Application No: EP/124/20/HH
Site Address: Little Dormers 23 Upper Drive East Preston BN16 1QN
Description of works: New bay and porch skirt roof to the front elevation, and roof linked detached double garage.

Thank you for your internet representation made on 3rd December 2020 which has been recorded as an objection with the comments as follows:

I am commenting on behalf of the East Preston and Kingston Preservation Society

Block Plan —
1:500

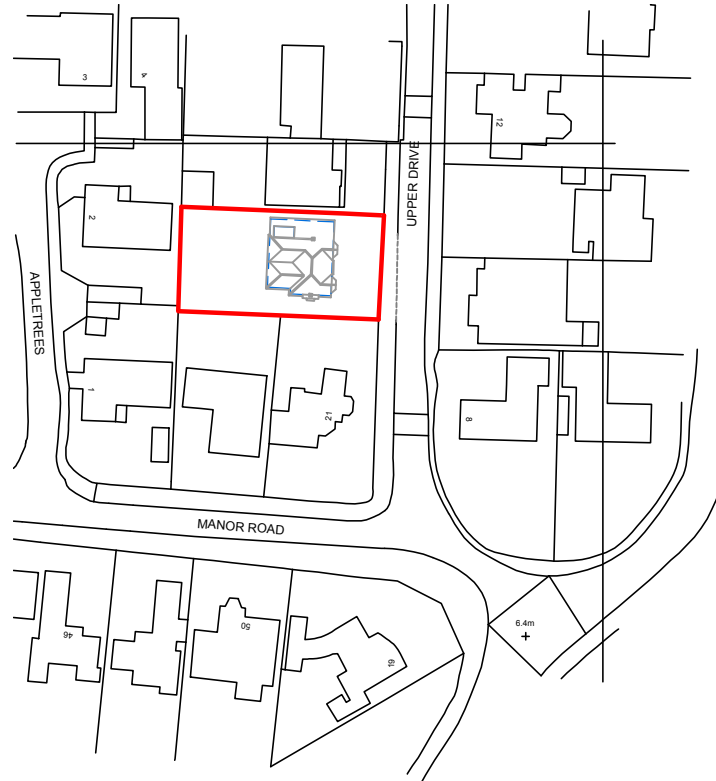
The proposal to place a double garage in front of the existing house, with its east wall about a foot from the street boundary of the plot, would have a severely damaging effect on the street scene and the character of the area. It would contravene the relevant policies of the Arun Local Plan and the East Preston Neighbourhood Plan. Indeed, it is the type of development that these Plans are intended to prevent.

East Elevation –
(Front) 1:100

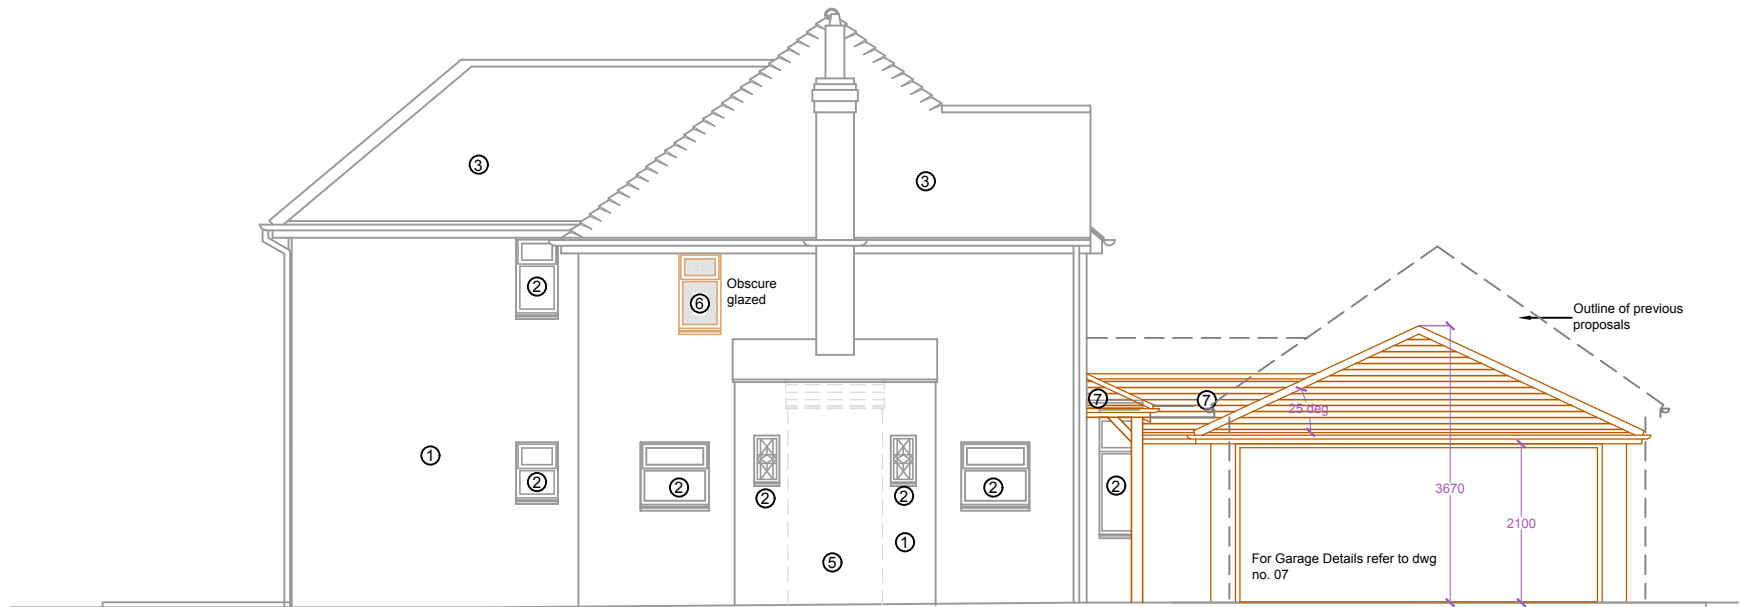
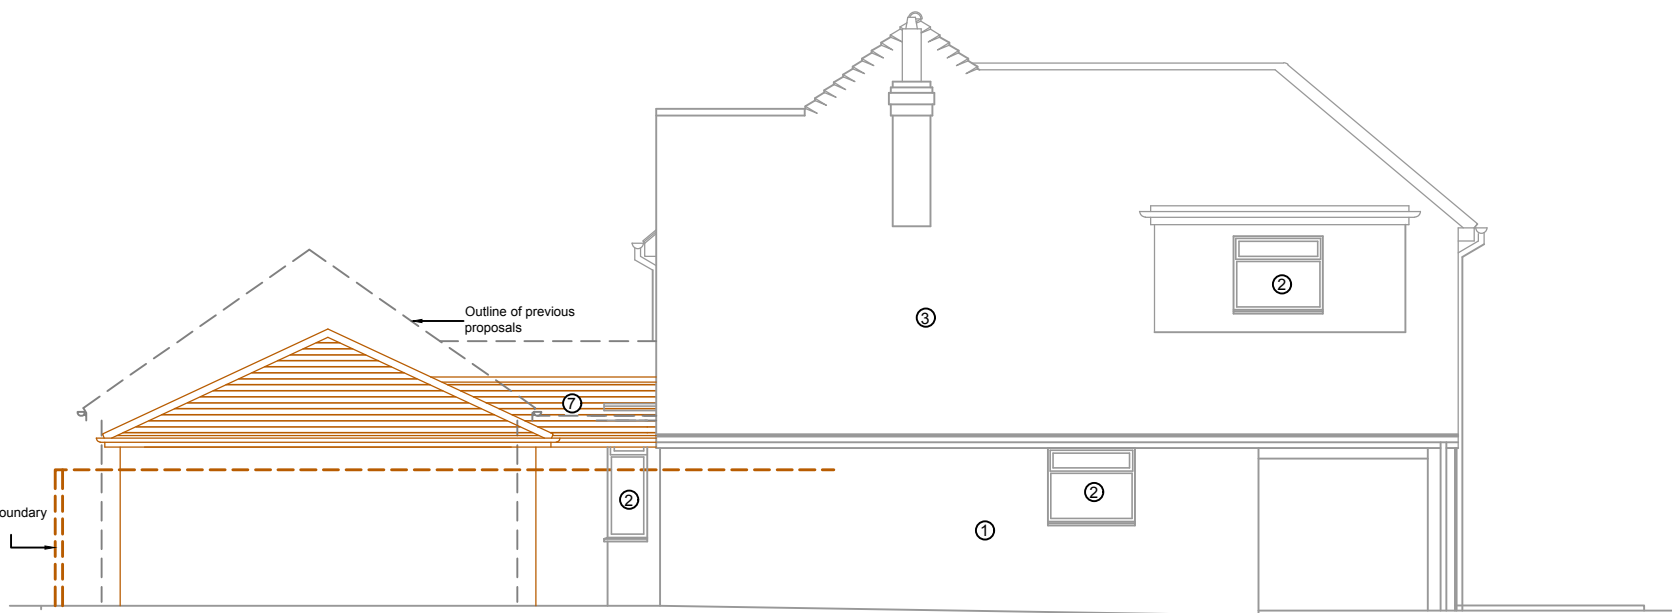
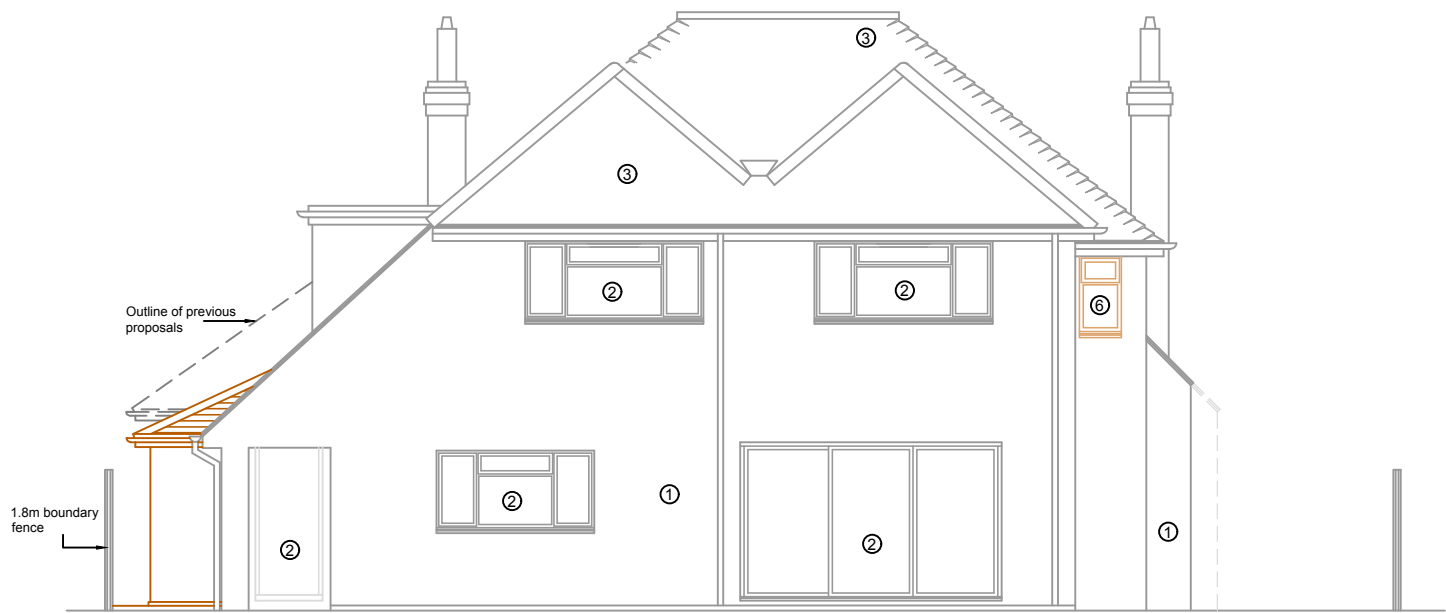
The drawings submitted with this application are defective and misleading. The drawing of the east and street front of the house only shows the roof of the proposed garage as a dotted line, and shows nothing of the rest of the proposed building. It shows the street front of the house as it is now, not as it would be if the proposed garage was constructed.
